DECISION DELEGATED TO DEVELOPMENT MANAGER

Application No: H18-0525-20 **Applicant:** Mr J Hook
Proposal: Erection of 2 dwellings - re-submission of H18-0191-20
Location: Adj. 236 Bridge Road Sutton Bridge Spalding
Terminal Date: 26th August 2020

GROUND FLOOR PLAN - PROPOSED
FIRST FLOOR PLAN - PROPOSED
ELEVATIONS - PROPOSED

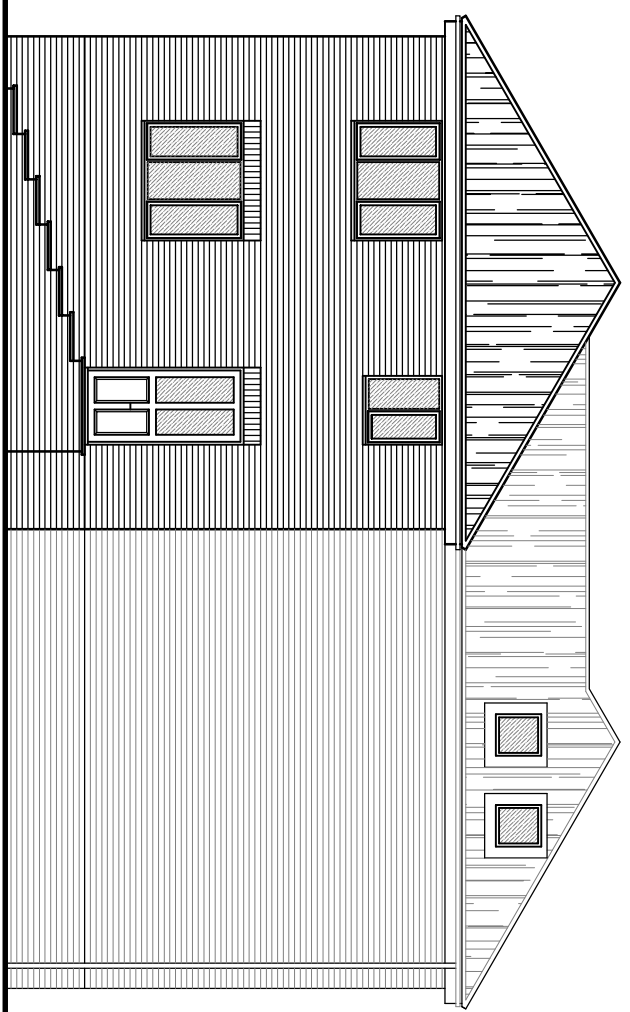
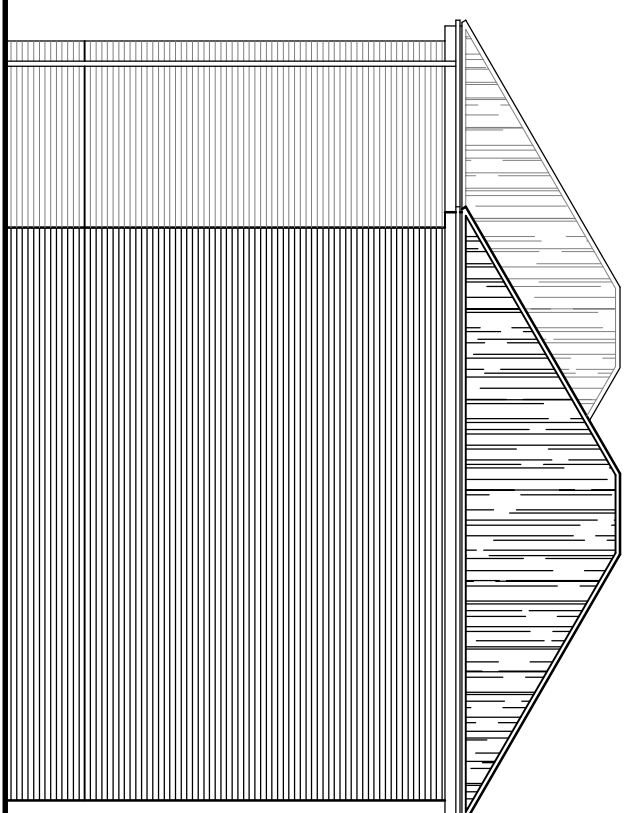
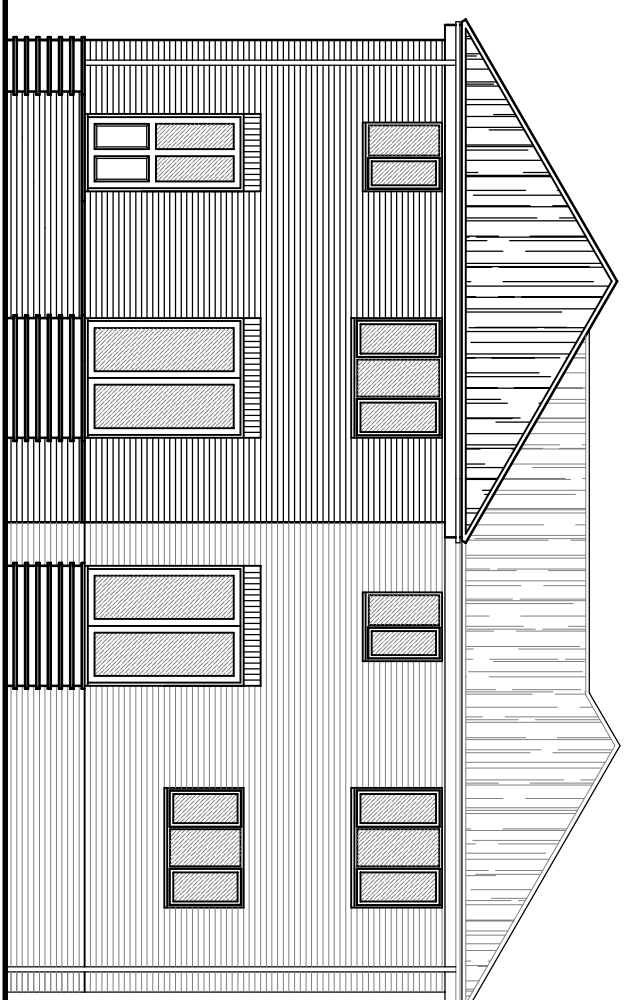
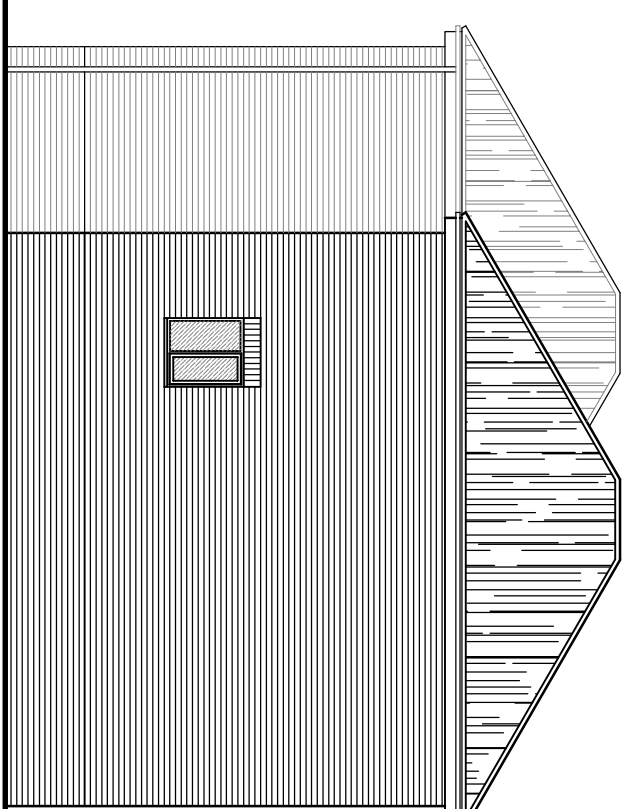
The proposed development would be set back behind no. 236 Bridge Road. It is considered that the proposal, by virtue of its scale, height and massing, would constitute an unsatisfactory and incongruous form of overdevelopment that would have an unsatisfactory relationship with no. 236 and harm the character/appearance of the street scene. This would be accentuated by the fact that finished floor levels would have to be raised by 1 metre to address flood risk.

In terms of amenity, the scheme has been designed to alleviate overlooking of neighbouring property at close range, subject to appropriate boundary screening. Overshadowing would not be such as to justify refusal, particularly taking into account the path of the sun. However, the level of activity upon the site and general comings and goings would be such that the amenity of neighbouring properties and no. 236 in particular would be materially harmed in terms of noise and disturbance.

Moreover, each dwelling, including no. 236 itself, would have limited garden or private amenity area, to the detriment of future occupiers of the properties.

The proposal, by virtue of its position, scale, height and massing, would constitute an inappropriate and incongruous form of development that would have an unsatisfactory relationship with no. 236 Bridge Road and also harm the character/appearance of the street scene. This would be accentuated by the fact that finished floor levels would need to be raised to address flood risk.

Also, the proposal would constitute a form of overdevelopment with limited private amenity space for future occupiers of the properties and occupiers of No. 236 Bridge Road. Moreover, the general level of activity upon the site, including the regular coming and going of vehicles, would be such that the amenity of neighbouring properties and no. 236 in particular would be materially harmed in terms of noise and general disturbance.
